RE:     **Sanctuary Pointe Filing No. 10 CDs**     **CCES Responses**

Your Construction Document (CDs) for Sanctuary Pointe Filing No. 10 has been reviewed by outside agencies and Town staff. Comments and necessary revisions have been compiled and are provided below. Some items are summarized in the interest of being concise and clear. Names and contact information are provided should you need to discuss any of the comments with the specific reviewer. Town comments are provided at the end of the letter; duplicate comments have been removed for your convenience. There may be additional comments/revisions as a result of your response to this first round of comments. We are happy to discuss any of these items, if necessary.

**Debbie Flynn, Planner II – Town of Monument**  
**719-488-1604, [dflynn@tomgov.org](mailto:dflynn@tomgov.org)**

DESIGNED BY	MAW	SCALE	DATE	6/18/21
DRAWN BY	PRA	(H) 1" = 50'	SHEET	4 OF 9
CHECKED BY		(V) 1" = 5'	JOB NO.	1100.61

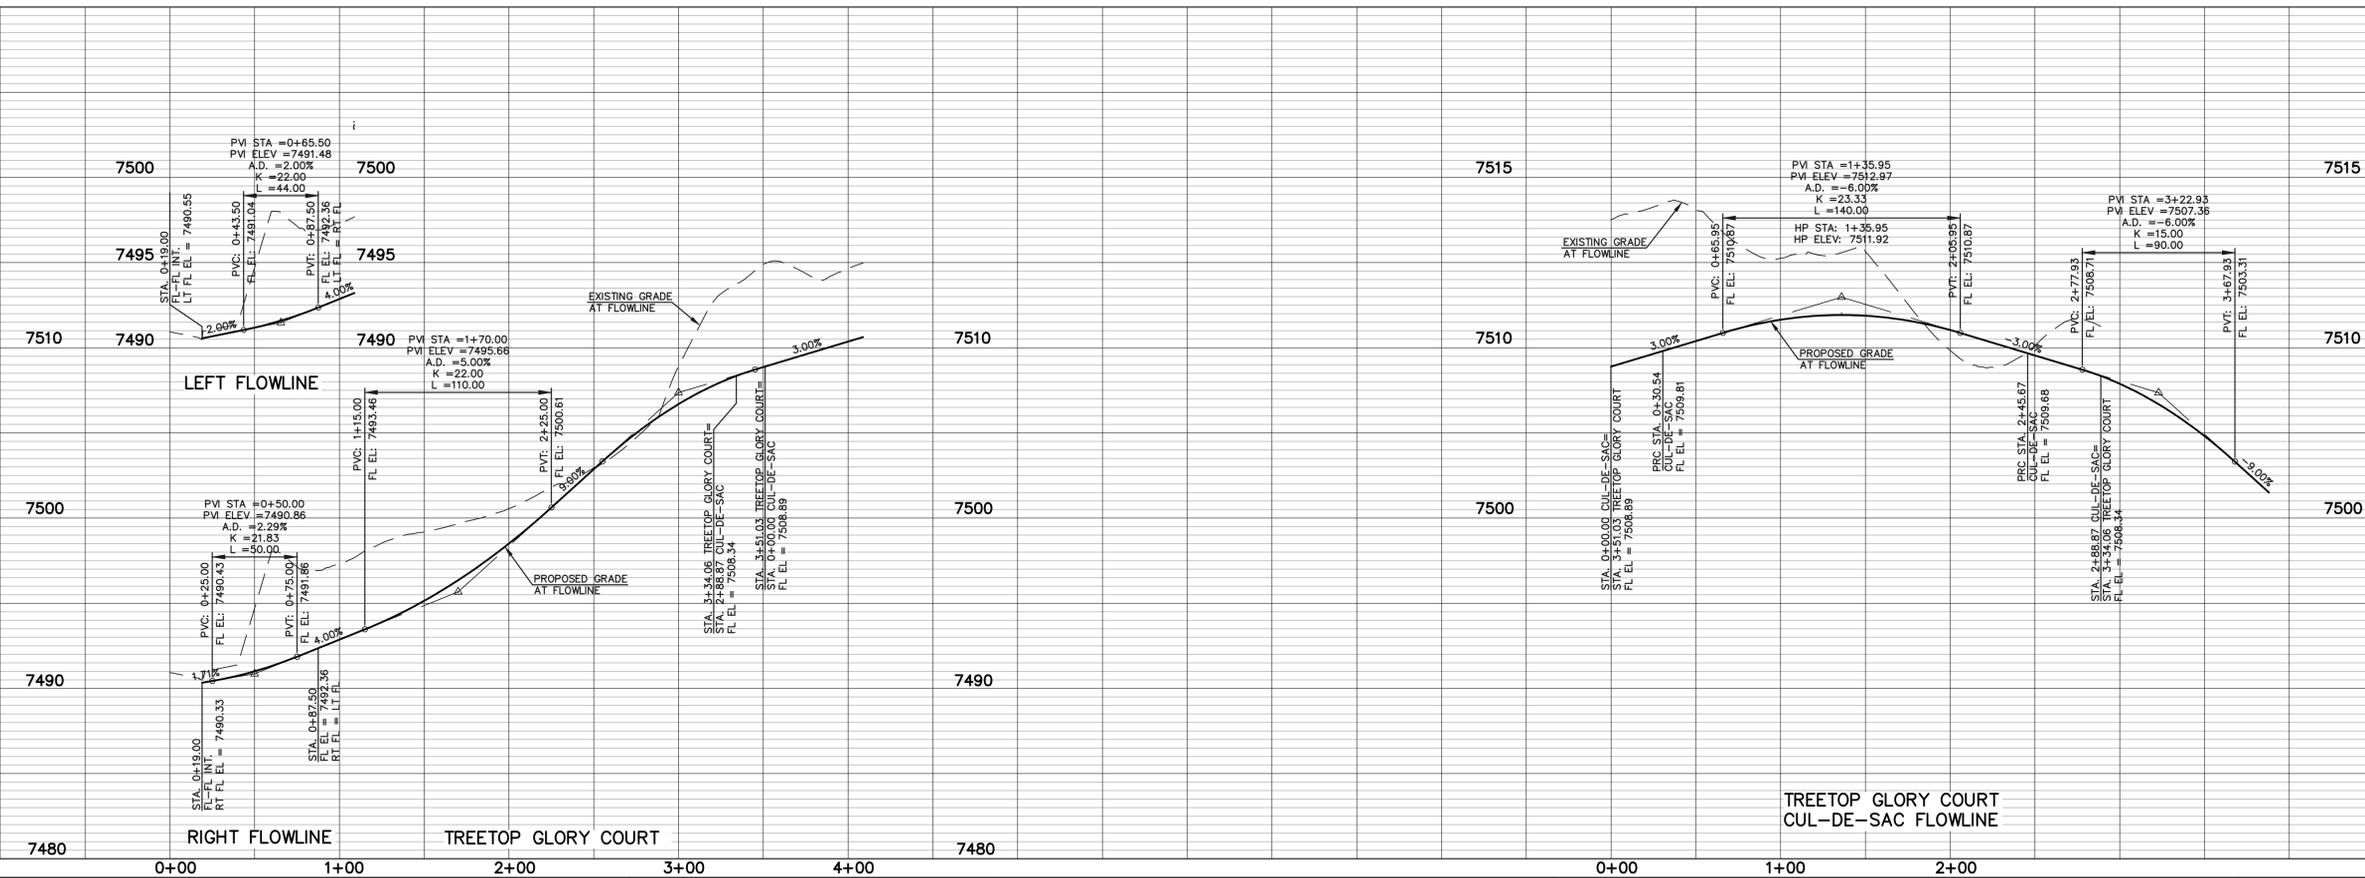
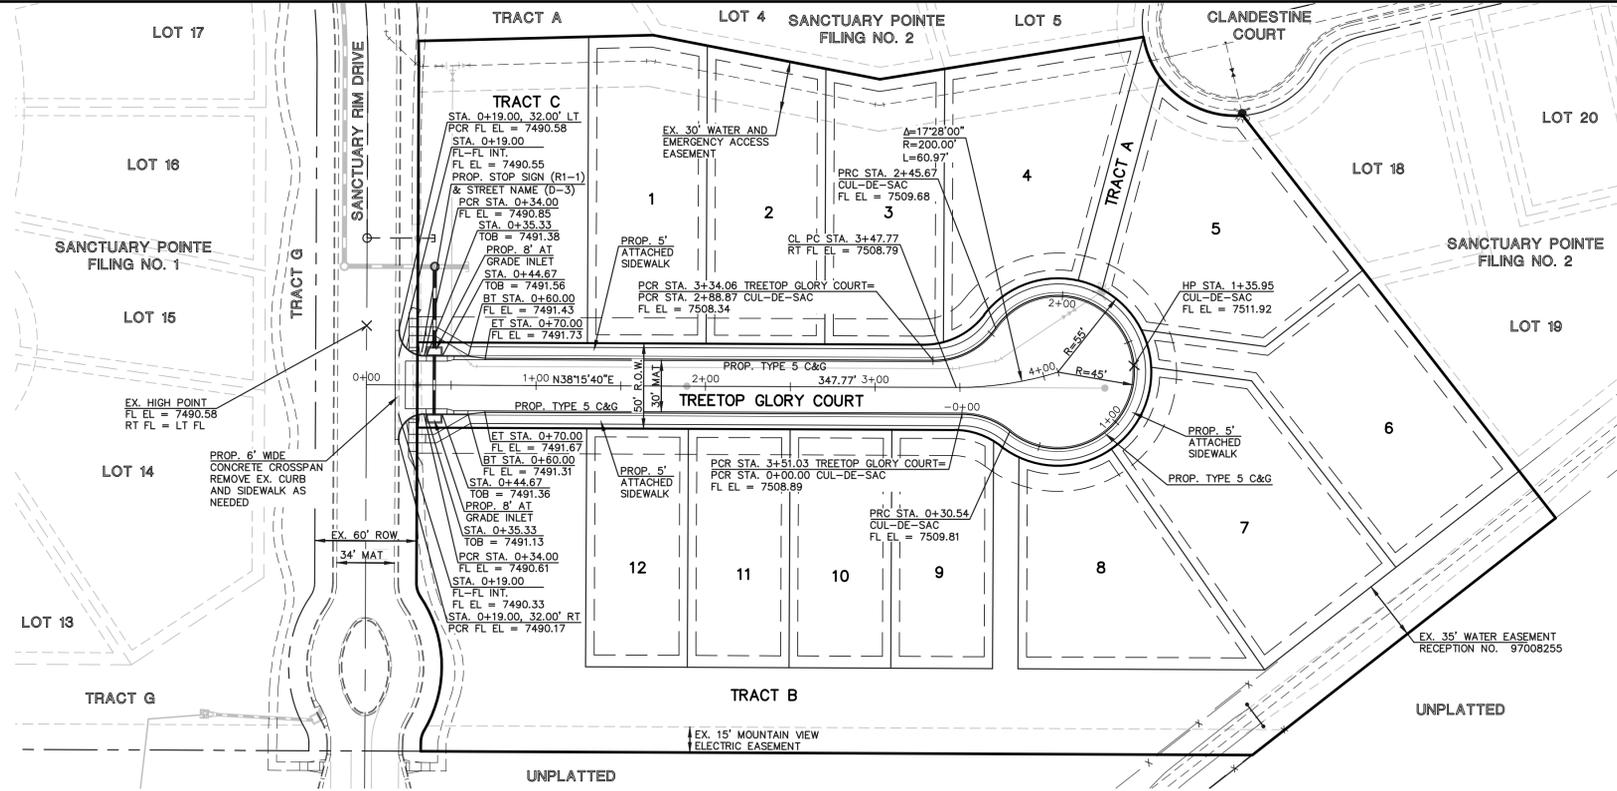
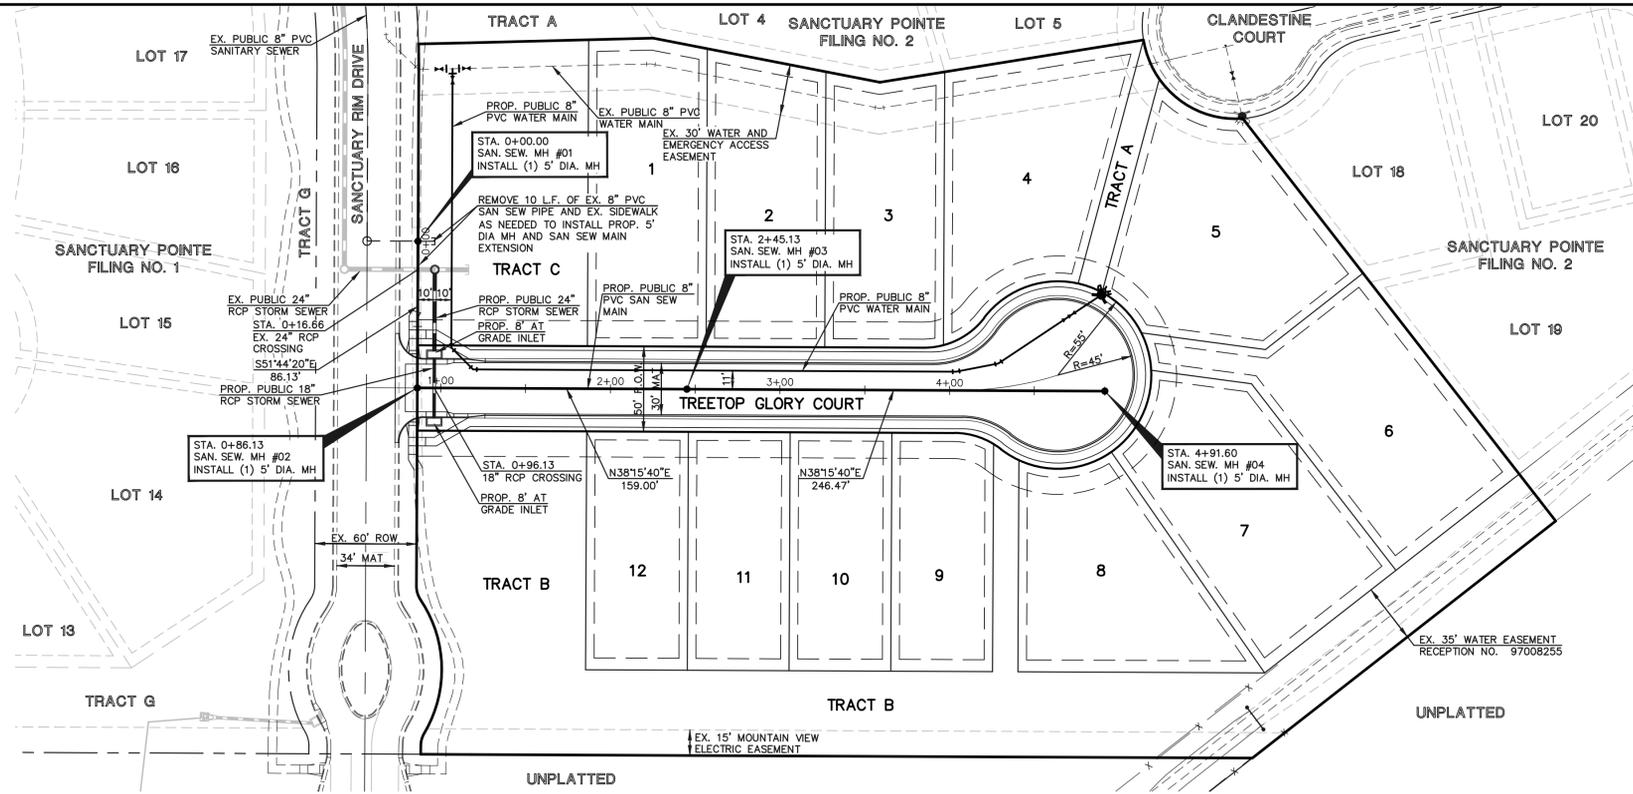
**Sheet 4:**

1. Is it required to have the No Outlet sign and the No Outlet sign with the street sign? **Added**
2. Please call out the street signs with symbol. **Added**
